Your ref: SSD 6799  
File no: MC-19-00001

**SSD6799-Mod-2 - New Cold Storage Facility Marsden Park**

## **ATTACHMENT A**

Title: **ELEVATIONS STAGE 1**

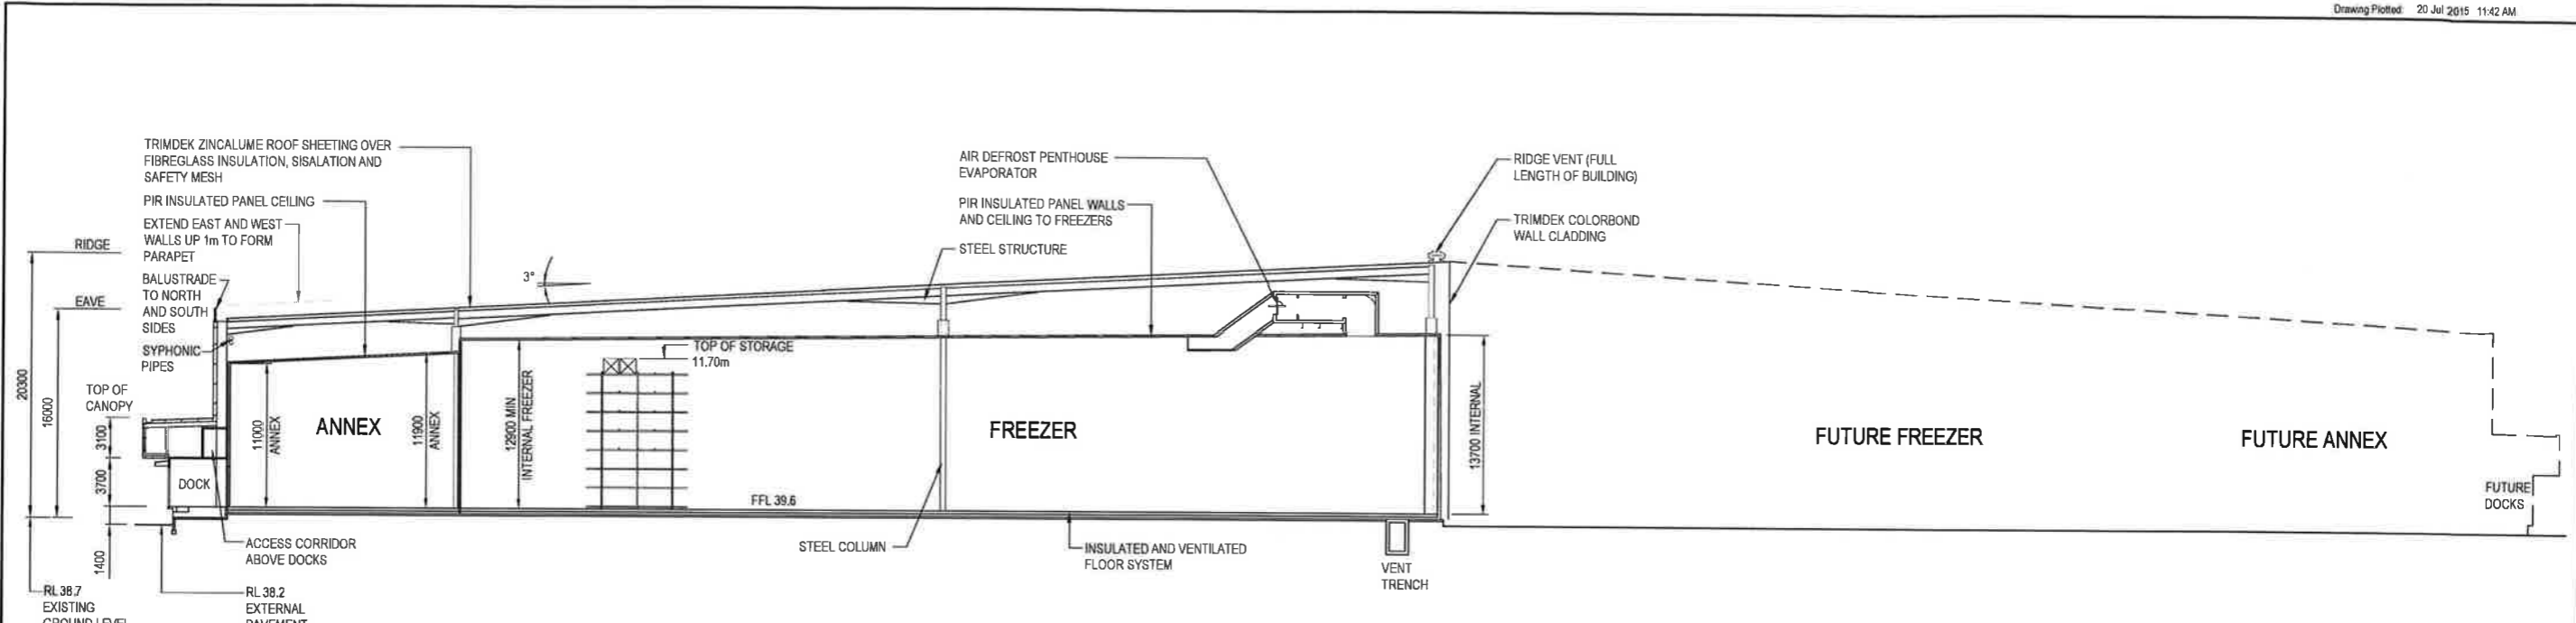
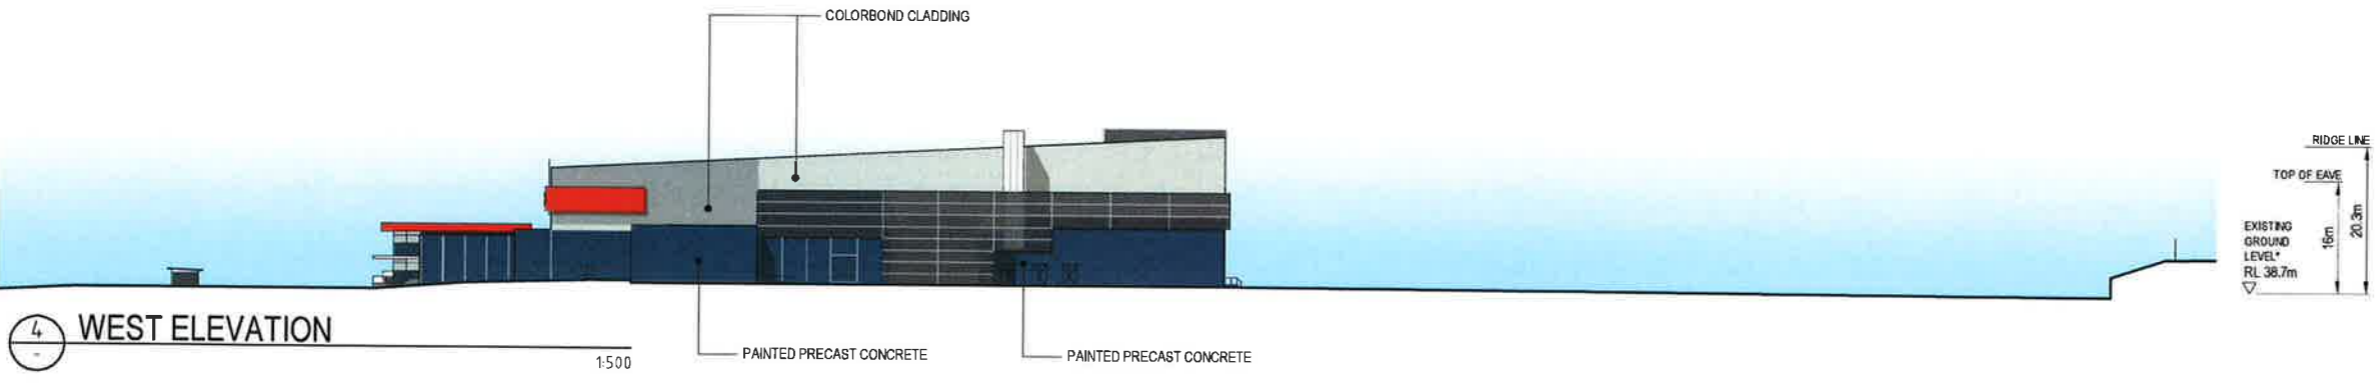
- The external materials used for the warehouse should not be highly reflective.
- There is an inconsistency between the traffic report and statement of environmental effects (SEE) in relation to the total gross floor area. The total gross floor area (GFA) specified under SEE is 37,276m<sup>2</sup>. The total gross floor area specified under the traffic report is 38,502m<sup>2</sup>. The applicant to clarify the exact GFA they are proposing under this modification application.

- The faceted metal cladding to the high-bay portion of the warehouse is important and efforts must be made to retain the full extent of the faceted metal cladding as originally proposed and supported by Council. It was on this basis we have supported the excessive height variation. On this basis Council requests that the entire extent of the high-bay receives the faceted metal cladding panels to achieve the design objectives of the proposal as per the previous approval.

Figure 5 | Proposed site plan (stage 1)

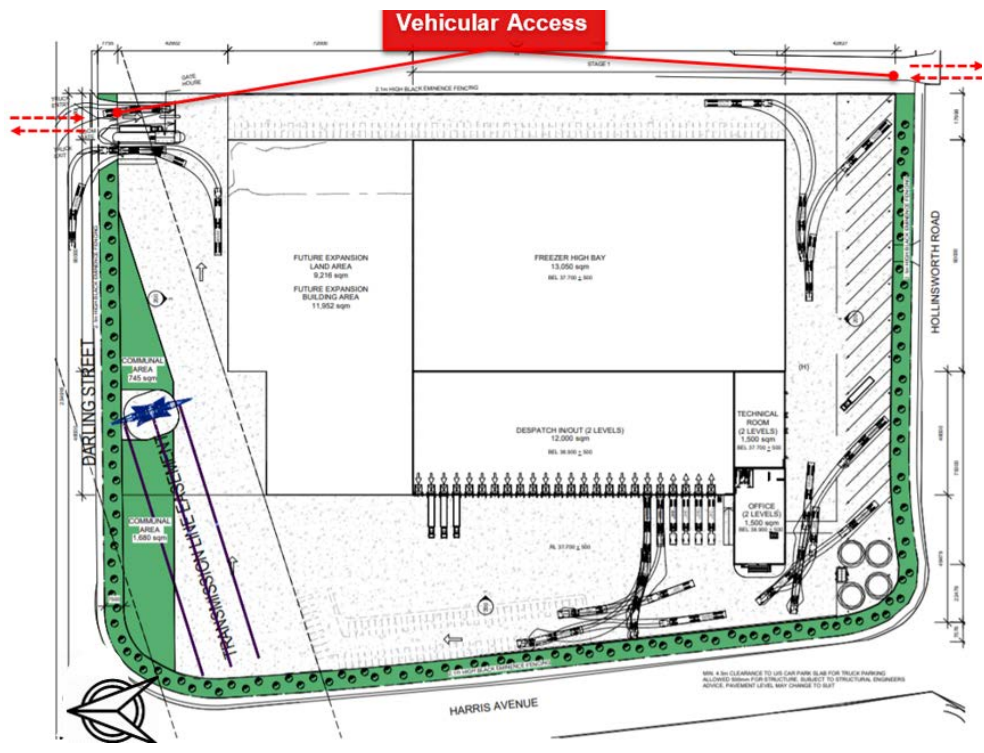
- Based on the proposed gross floor area (GFA) as indicated in the submitted traffic report, a total of 286 car parking spaces are required. The development maintains 133 spaces, resulting in a shortfall of 153 spaces. The current parking provision is therefore not compliant with our requirements. Whilst the proposed modified facility may not necessitate compliance with the required spaces, the applicant shall provide a provisional parking plan demonstrating future compliance with car parking in the event that the facility was to undergo a change of use in the future.
